From: Simon Davis
Sent: 13 April 2026 16:56
To: Darryl Howells [REDACTED]
Subject: RE: Acknowledgement for BE/15/26/PL

Proposed Site Plan
1:200

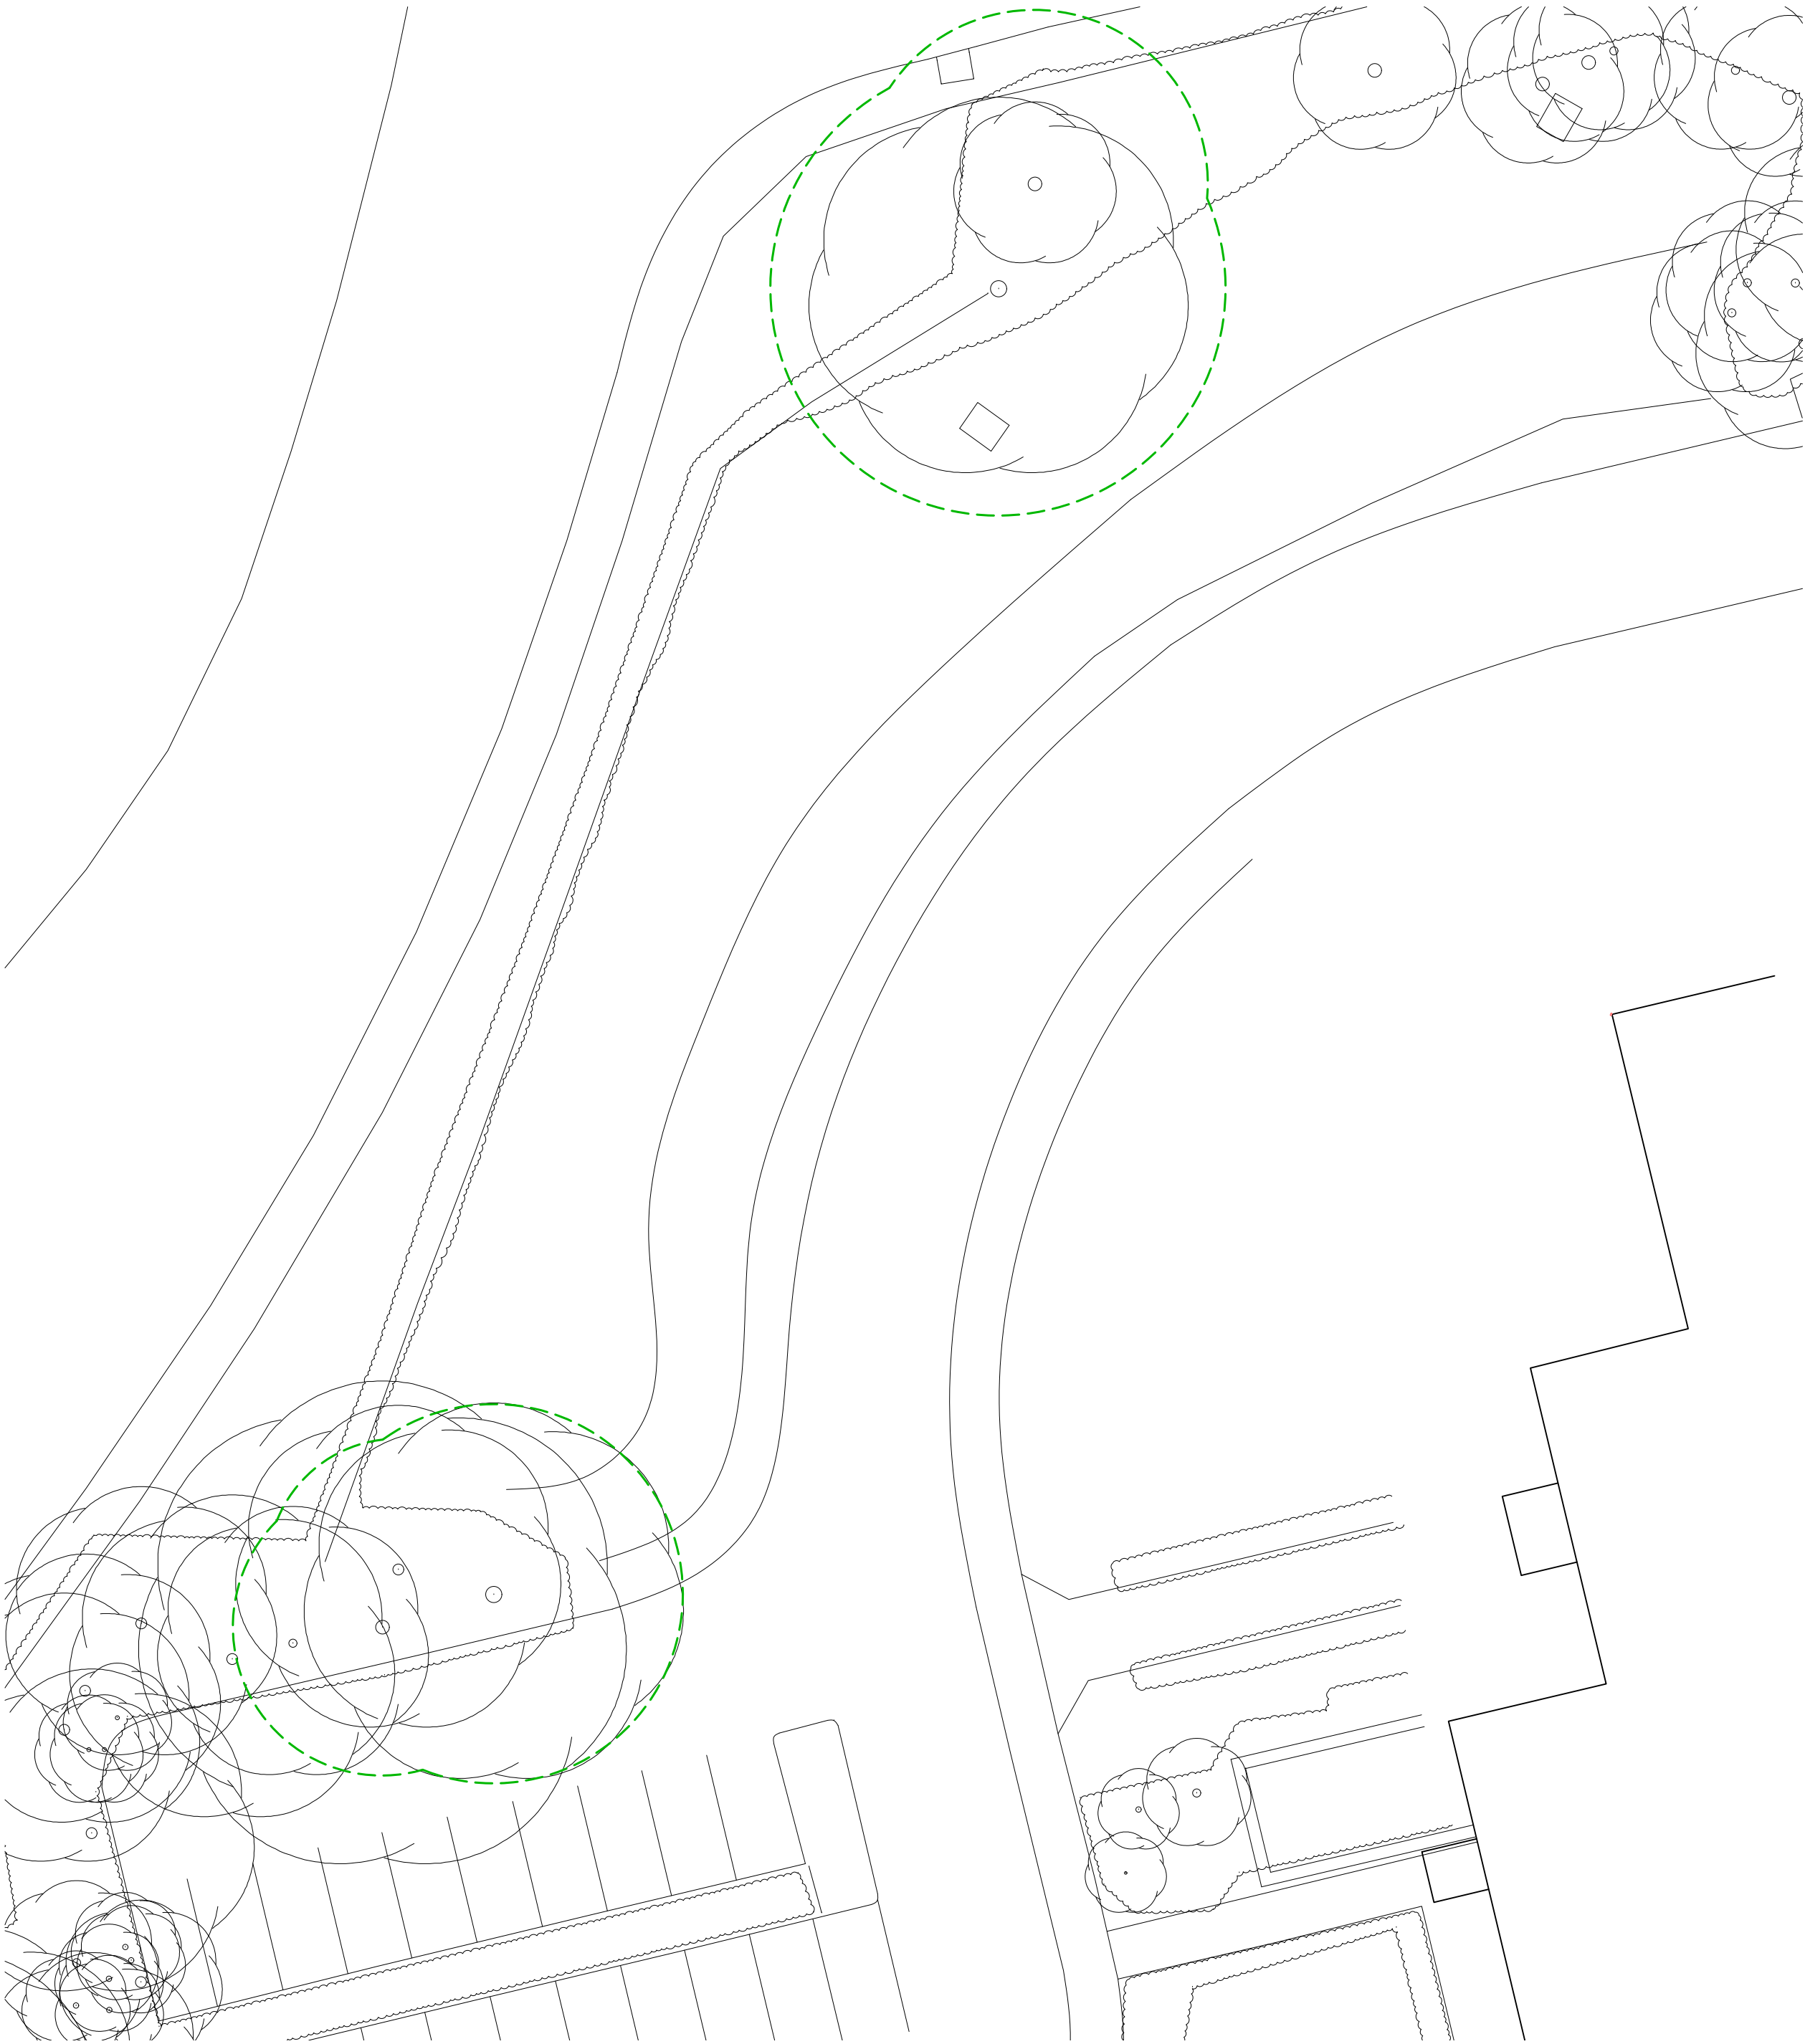
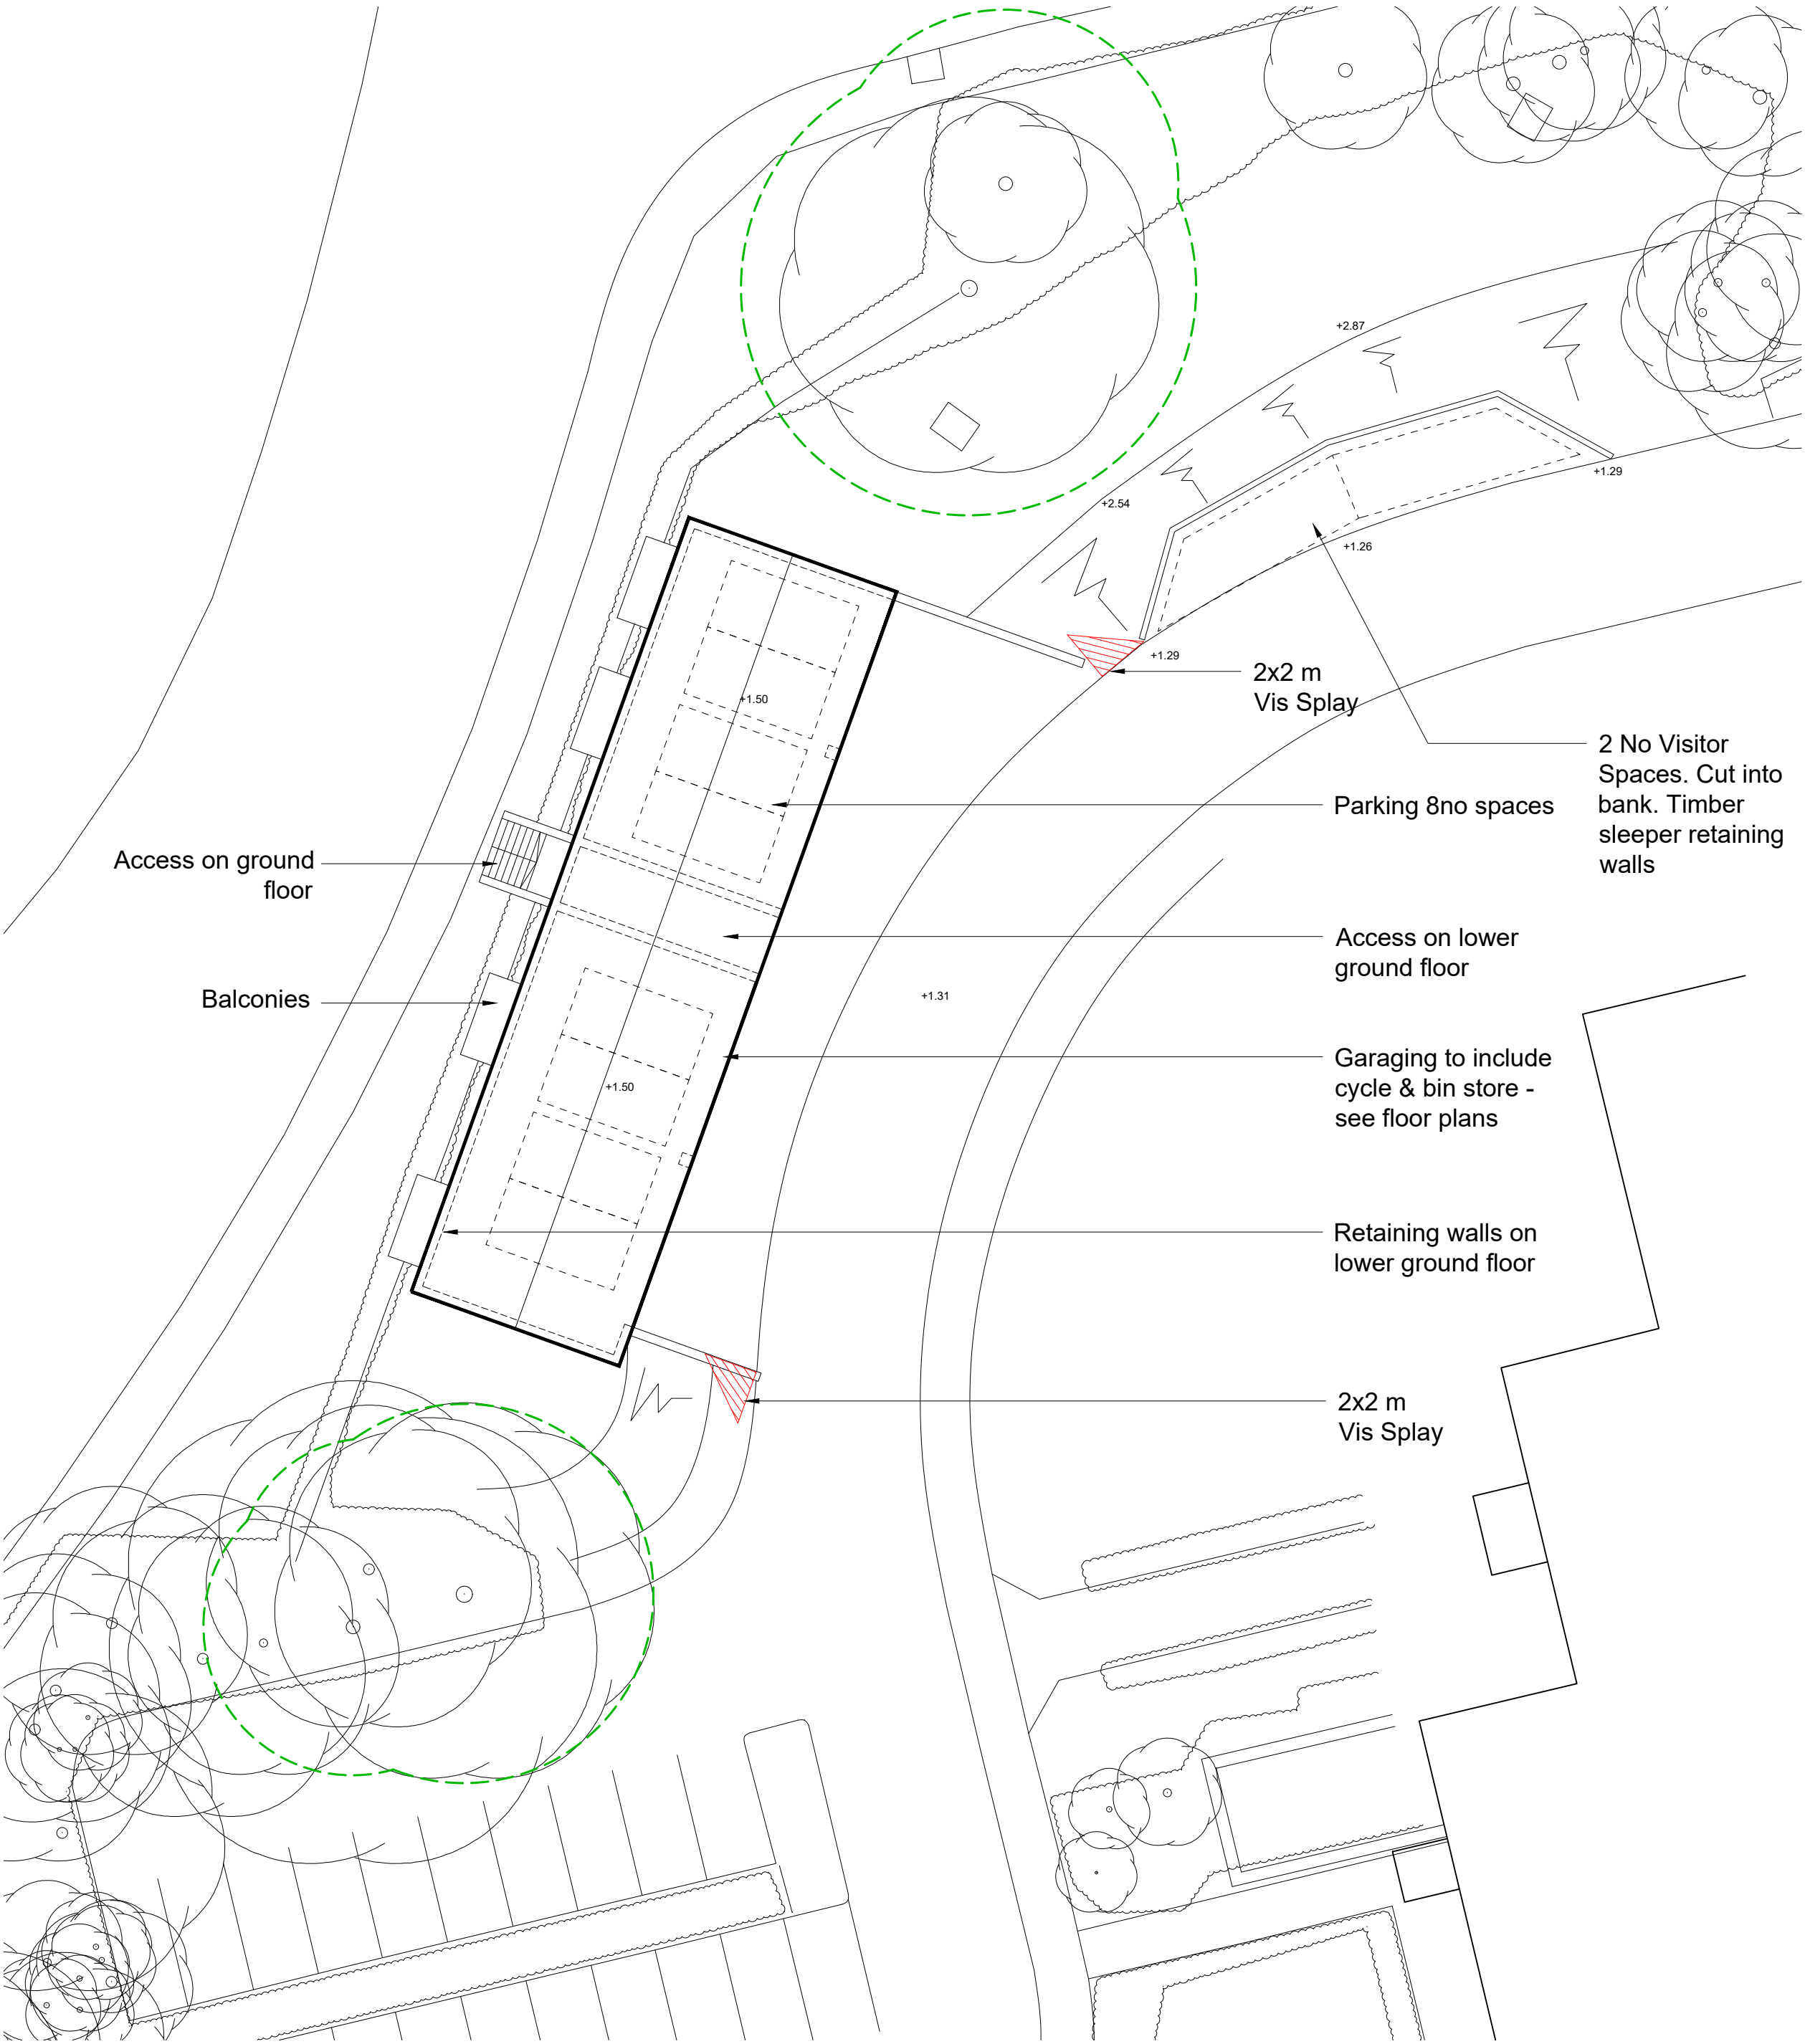
I see that two extra visitor spaces are now included which is positive*. I see no reason to take a different view to the previous report.

* However, these are close to the TPO trees on the site and so I have also requested advice from our Tree Officer, He is on leave this week.
